Application no: 22/00217/DISC

Location: Begbroke Science Park, Begbroke Hill, Begbroke, OX5 1PF

Transport Development Control

drawing title: Cycle Path Arrangement Drawings 2 of 2

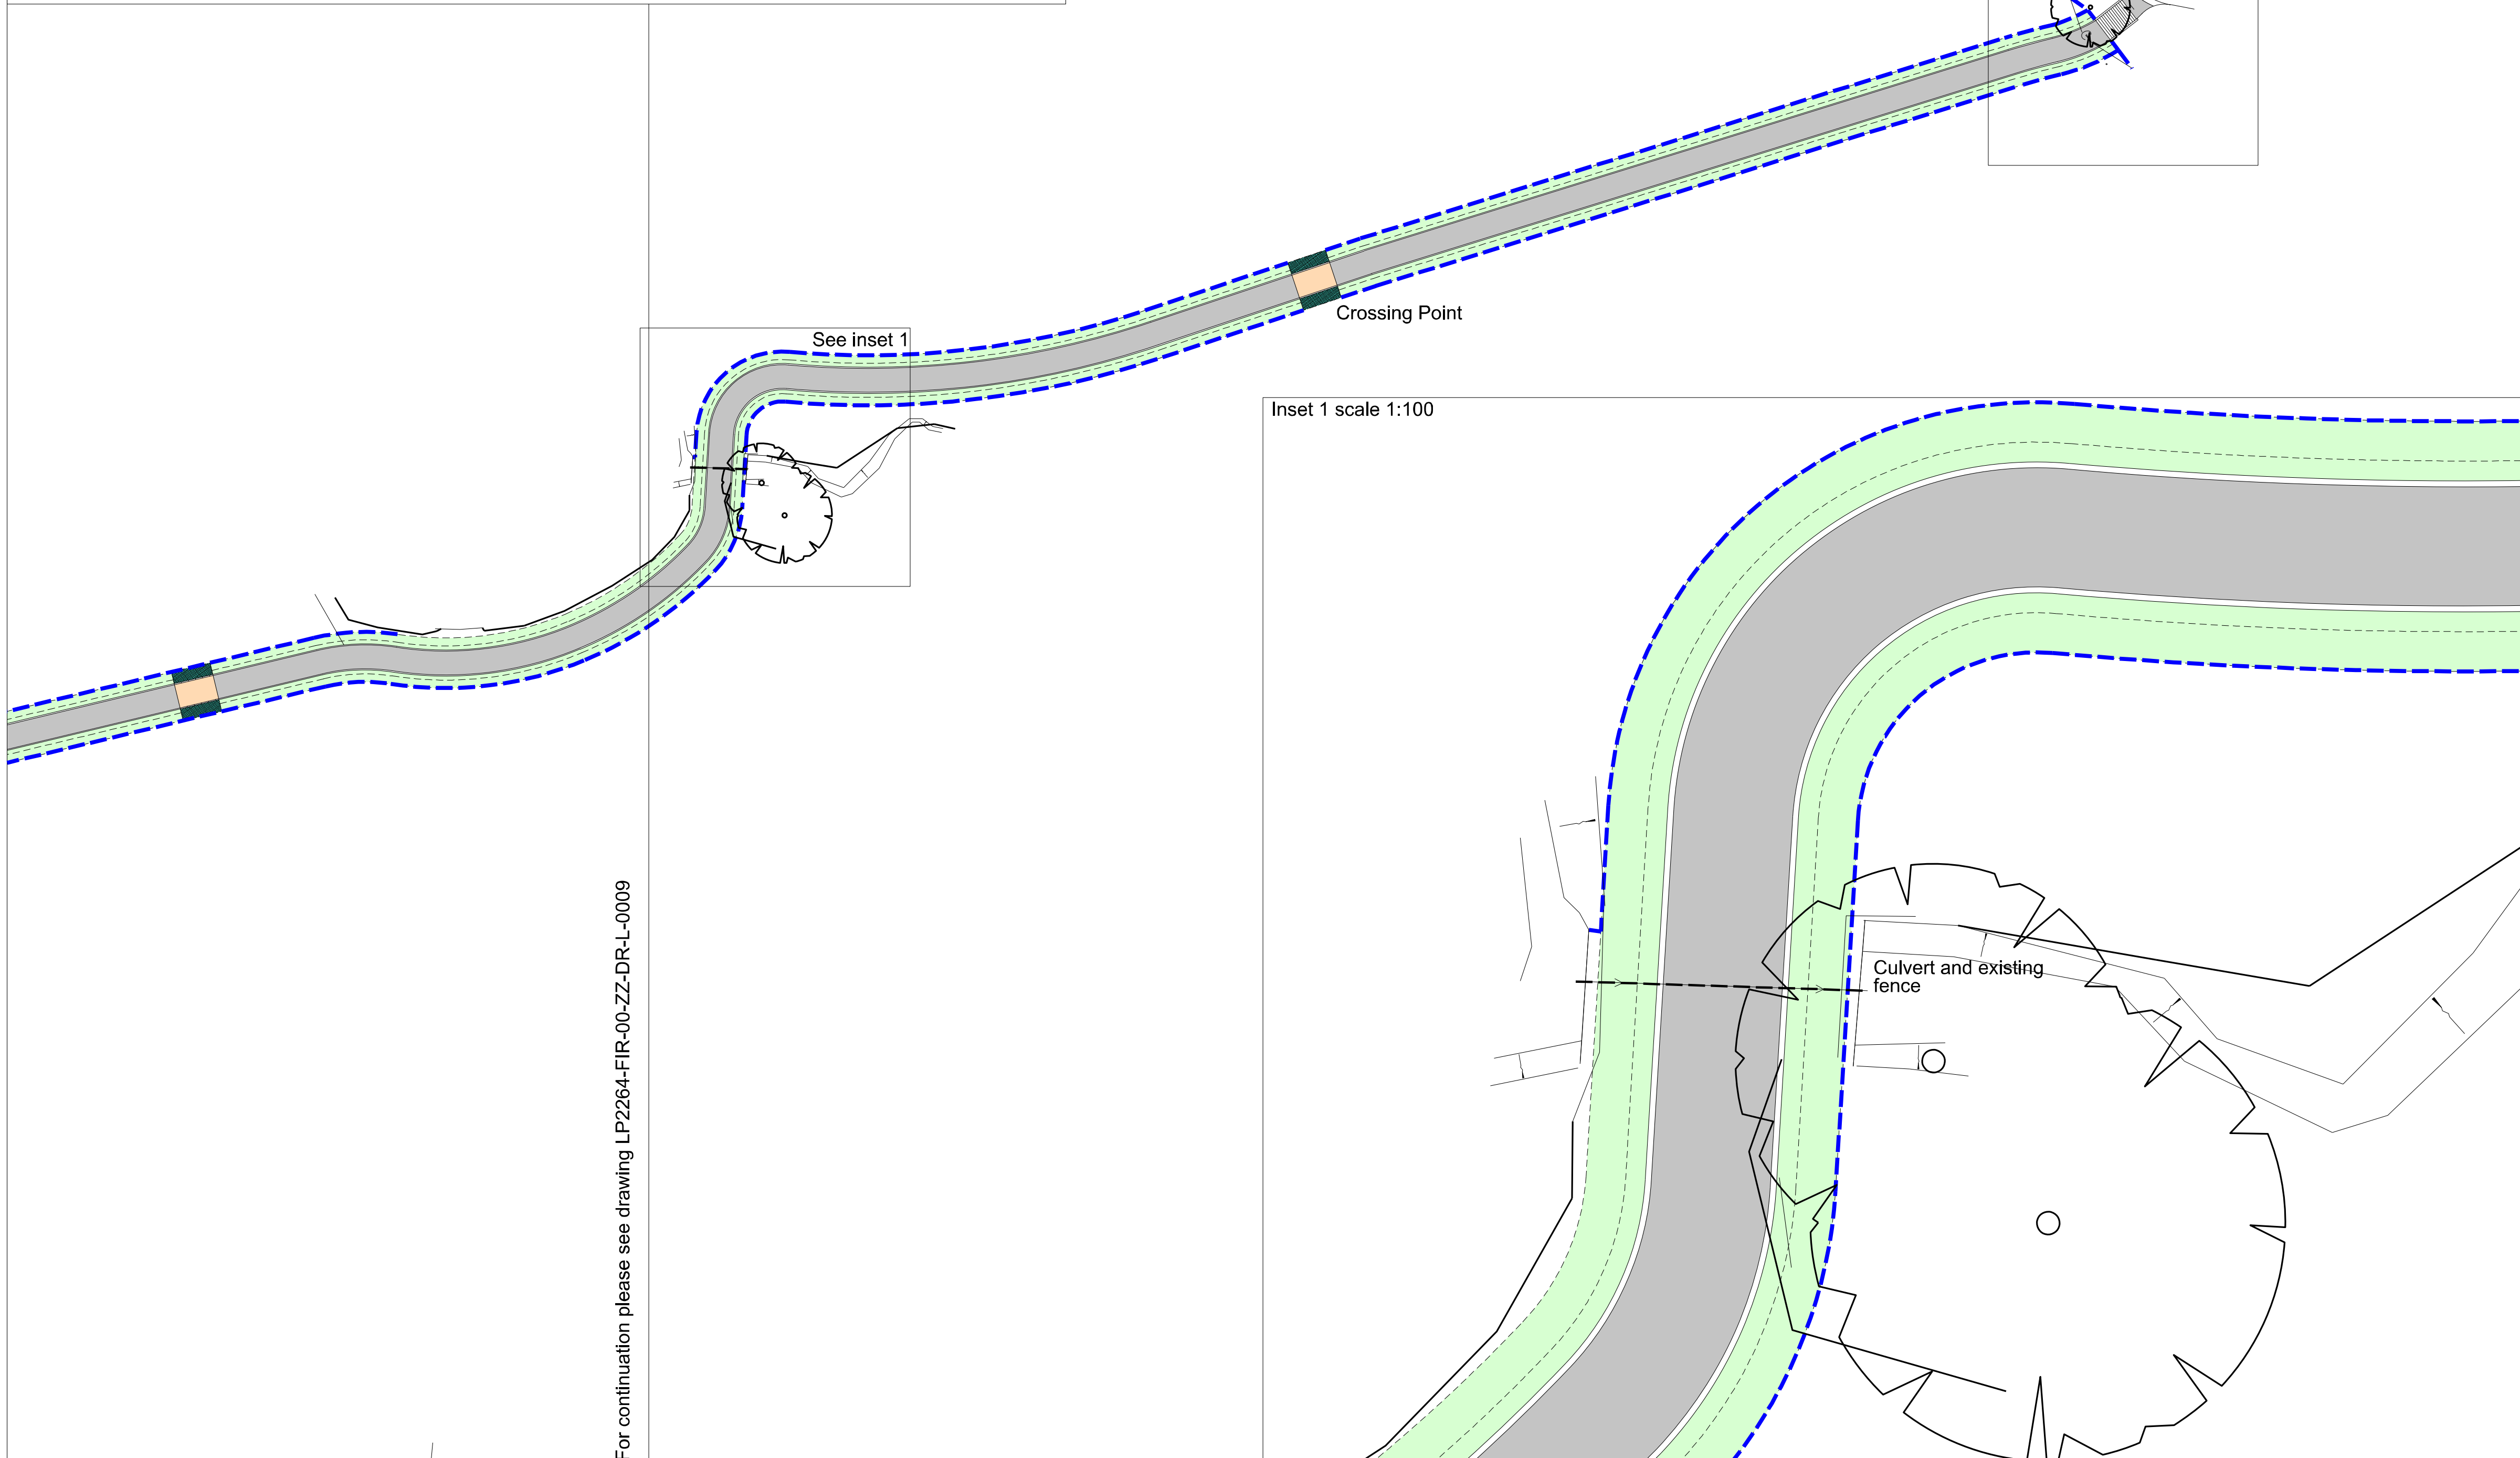
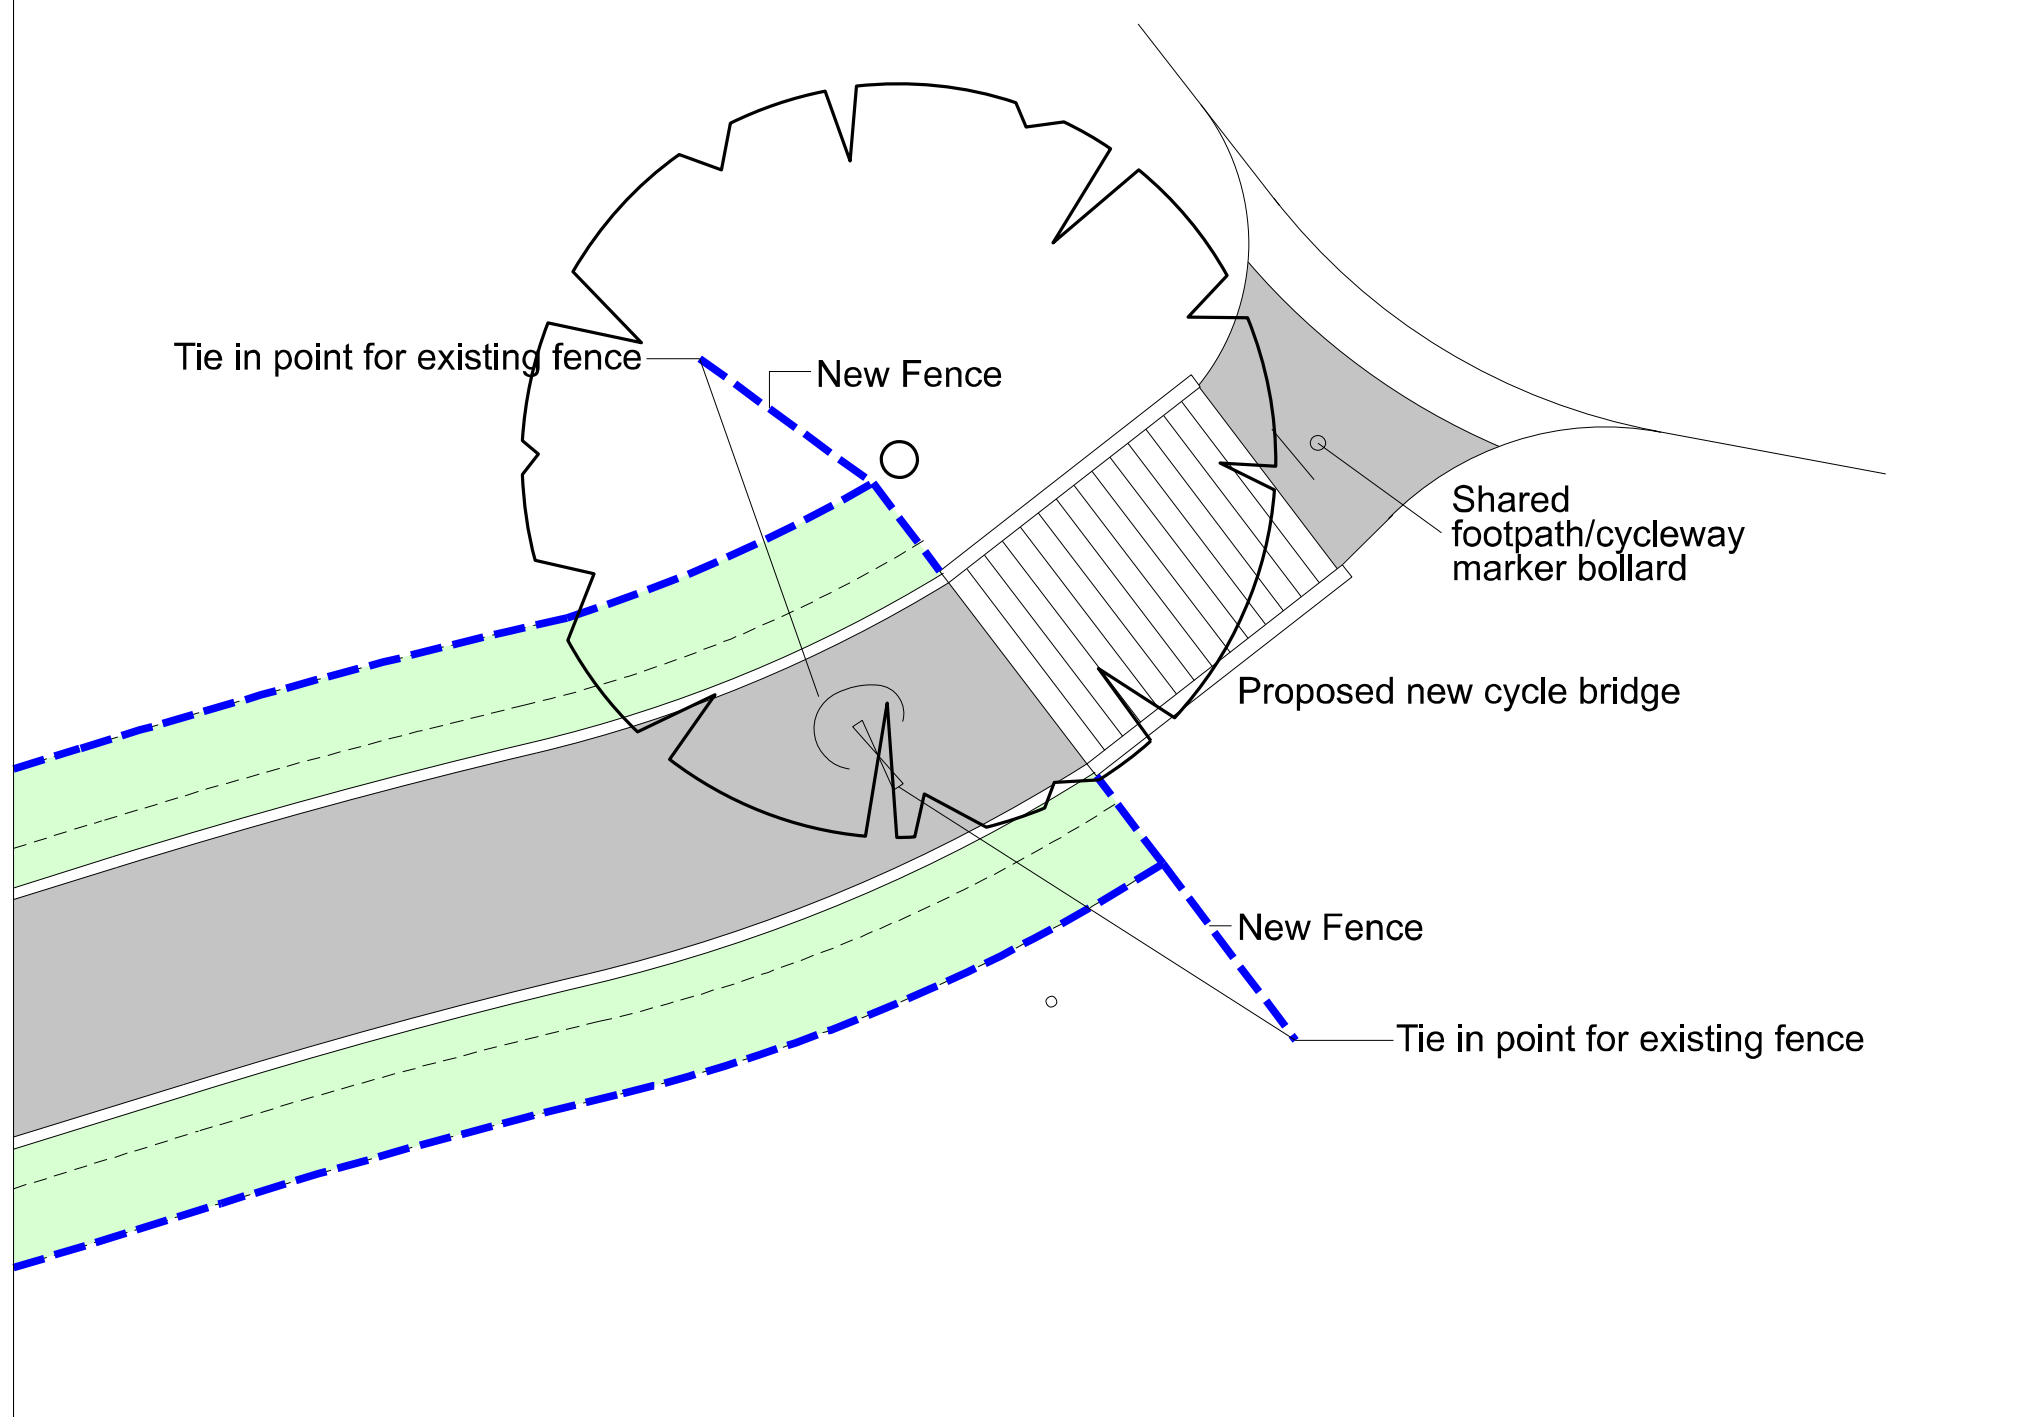
The routing and specification appear to be suitable for the permissive pedestrian / cycle path.

I note that the path is due to be completed by the end of 2023.

Provision of the path's continued maintenance and repair over the lifetime of the scheme must be made.
